# BUILDING PERMIT

Located At 693 FOREST AVE

Job ID: 2012-02-3298-ALTCOMM

has permission to Do interior alterations for future tenant, ADA bath, walls, roofing, ACT ceiling, enclose lift shaft provided that the person or persons, firm or corporation accepting this permit shall comply with all of the provisions of the Statues of Maine and of the Ordinances of the City of Portland regulating the construction, maintenance and use of the buildings and structures, and of the application on file in the department.

Typical Wall at elevator Shaft
All doors in and out of shaft to
be 60 min UL Listed fire doors
Wall Type 3

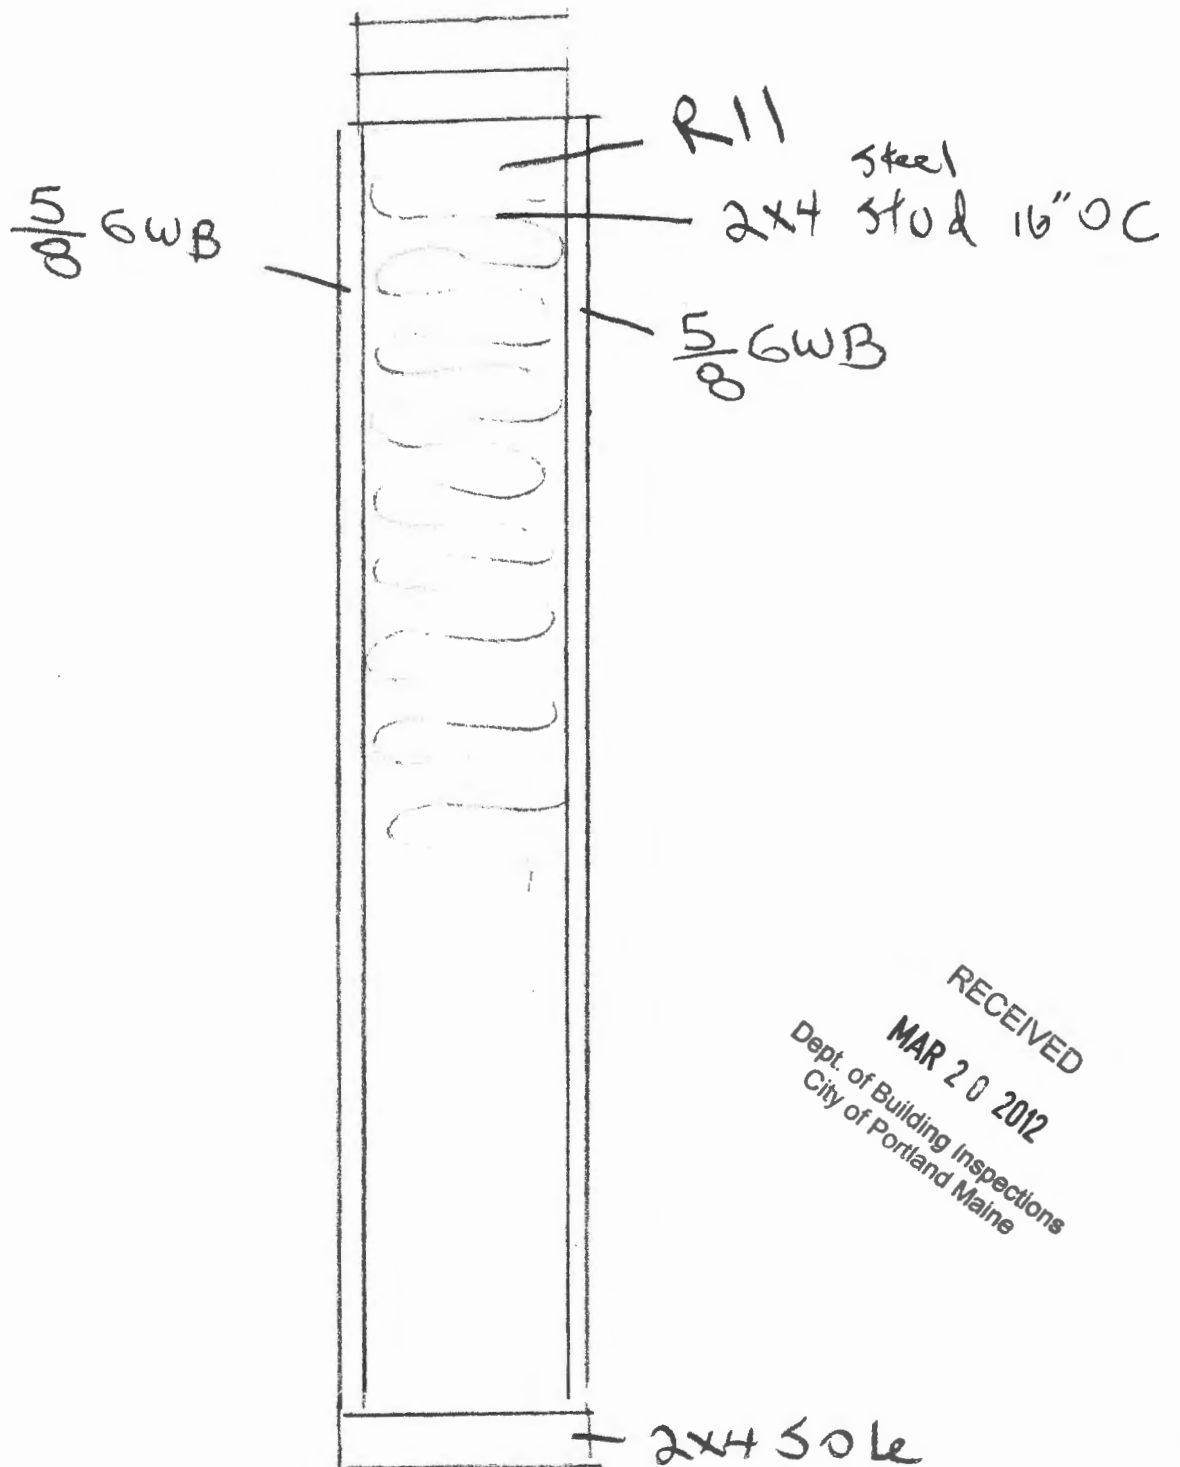
4. Vertical openings (Shafts) shall be 60-minute fire rated including fire door assemblies.
5. Any Fire alarm or Sprinkler systems shall be reviewed by a licensed contractor(s) for code compliance. Compliance letters are required.

To reiterate what we discussed on the phone this after noon, this is not a tenant fit up permit but construction only in preparation for a possible future tenant. The scope of work under this permit is to install an ADA bathroom; two exterior window assemblies on the Vannah Street side of the building; build a partition wall for a proposed future kitchen space; and repair a shaft that connects the basement with the top floor level for an existing material lift. A separate fit up permit will be required prior to any certificate of occupancy and will have to provide a life safety plan for the entire space as well as kitchen equipment and use plan(s). The conditions on this permit will reflect this and that the shaft must be 60-minute fire rated including fire doors.
